**CITY OF ALBUQUERQUE
PLANNING DEPARTMENT
December 6, 2006
DRB Comments**

PROJECT #1004496

APPLICATION # 06-01666

RE: Lots 1,1A,1B, & 1C, The Bluffs @ Encantado/fp

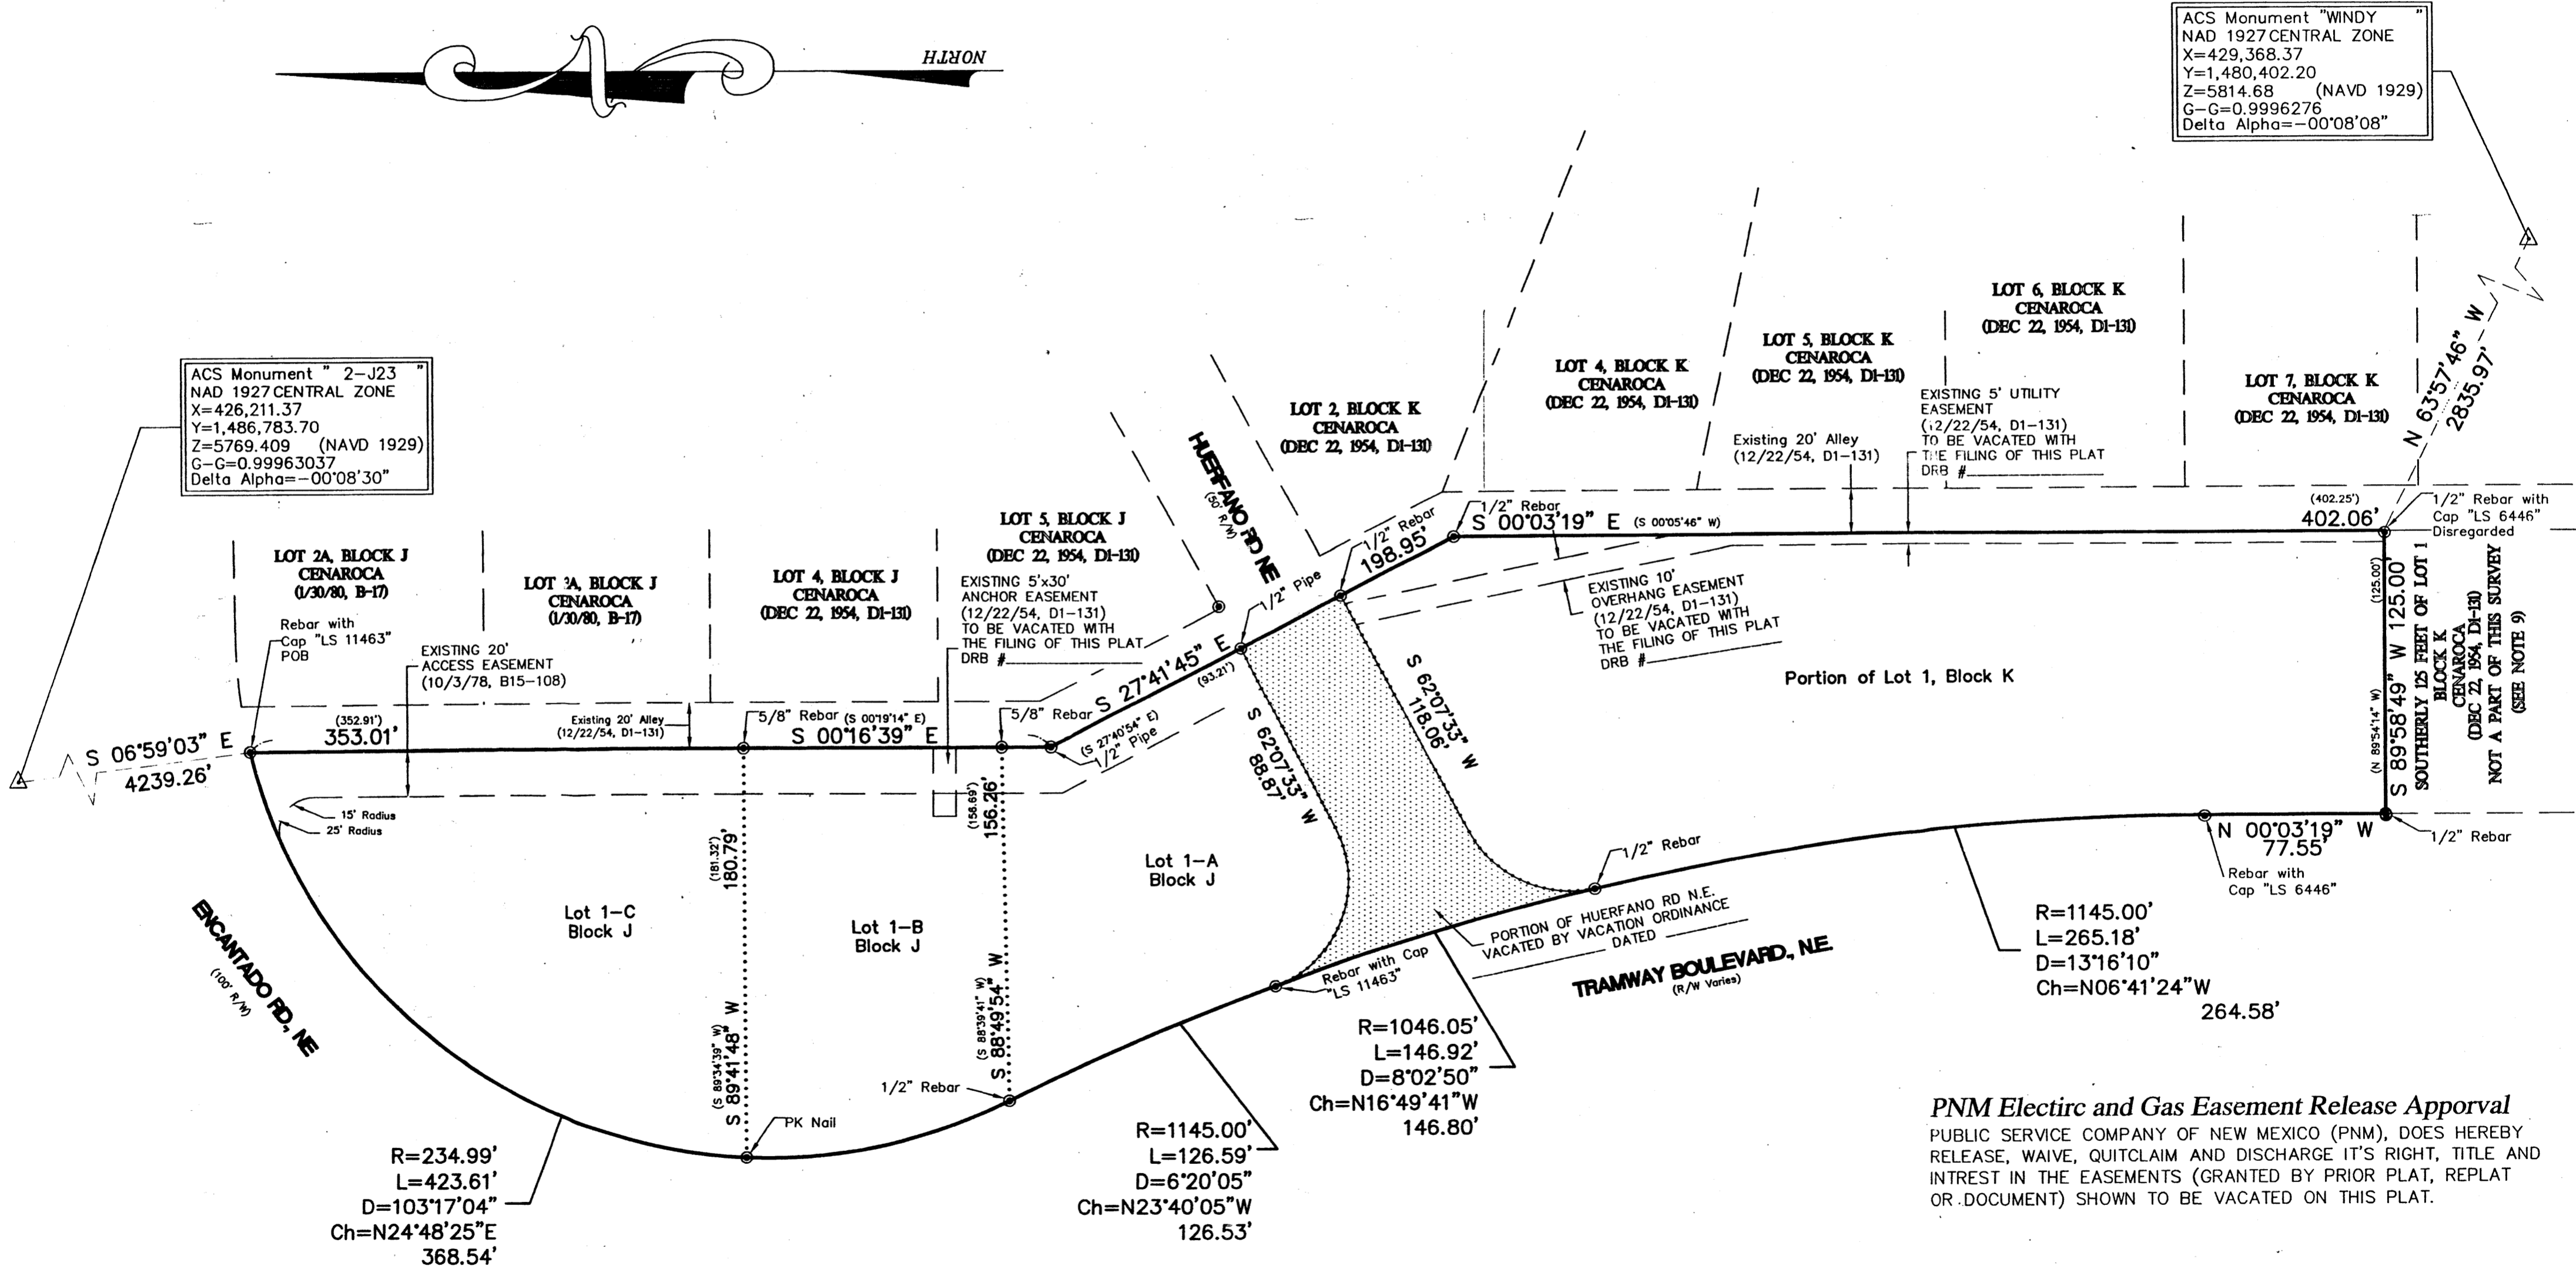
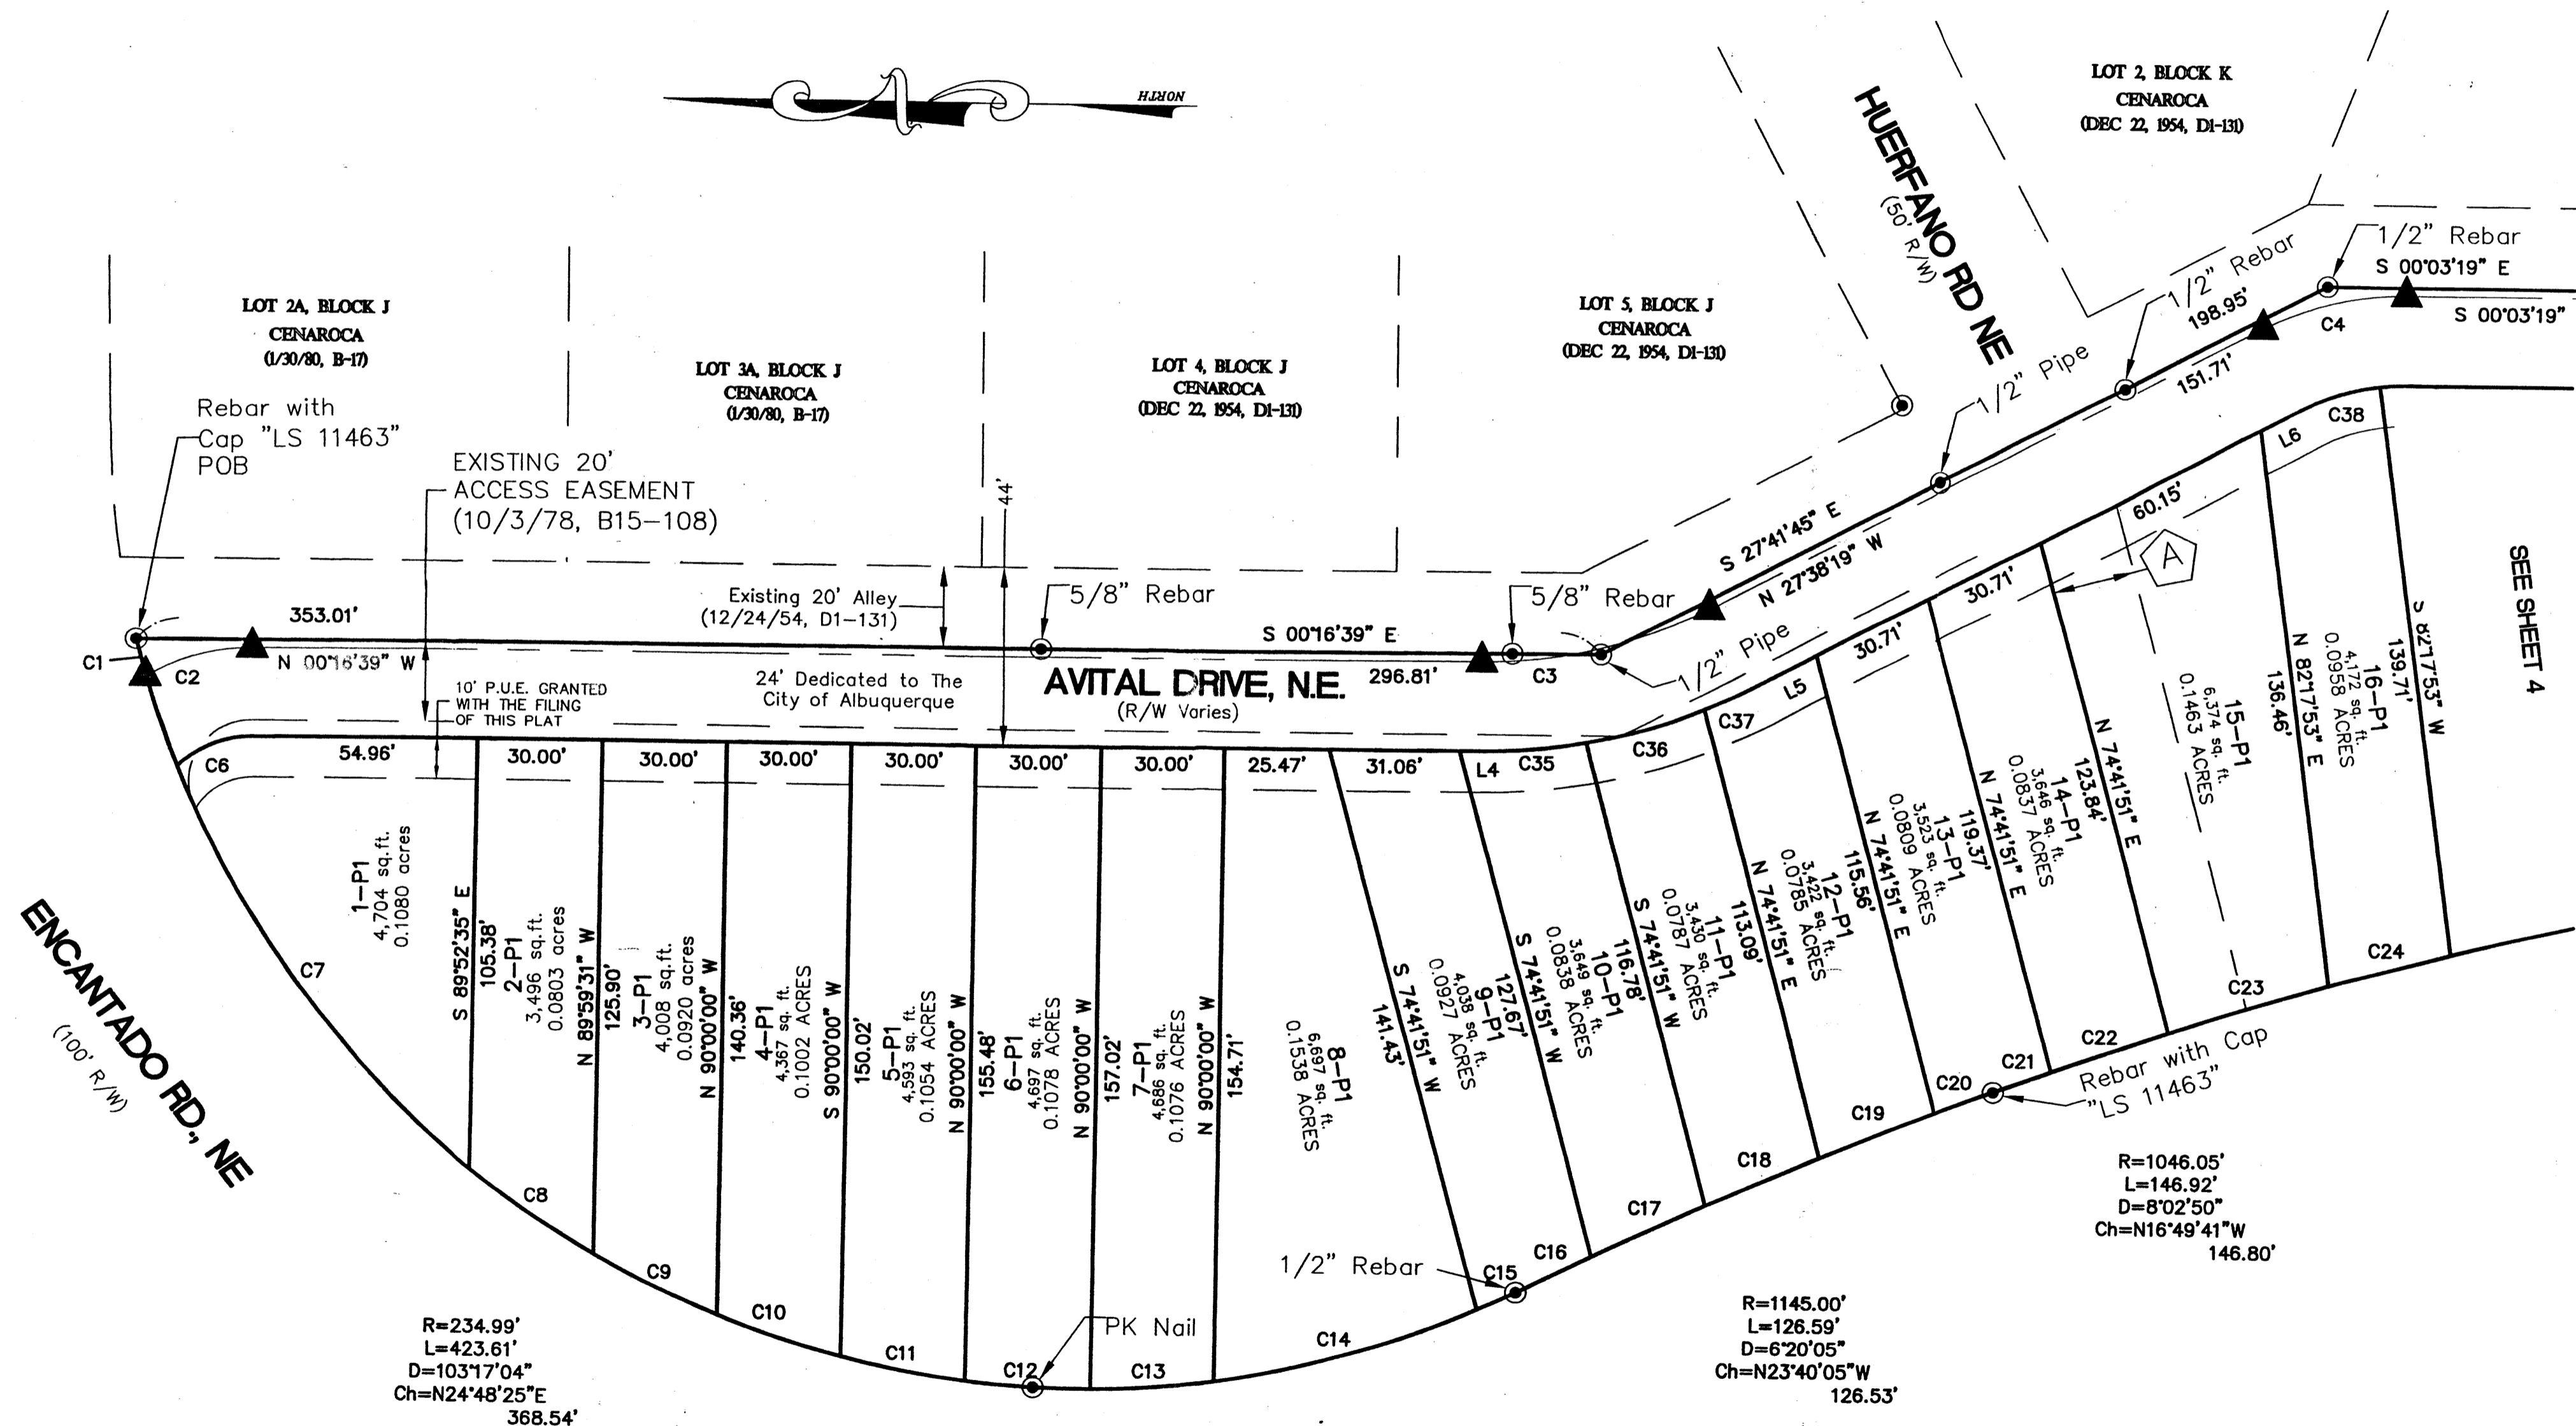
lots 2-PI & 3-PI must be 30'

There are two lots (2-P1 & 3-P1) that do not meet the minimum lot width of 30 feet.
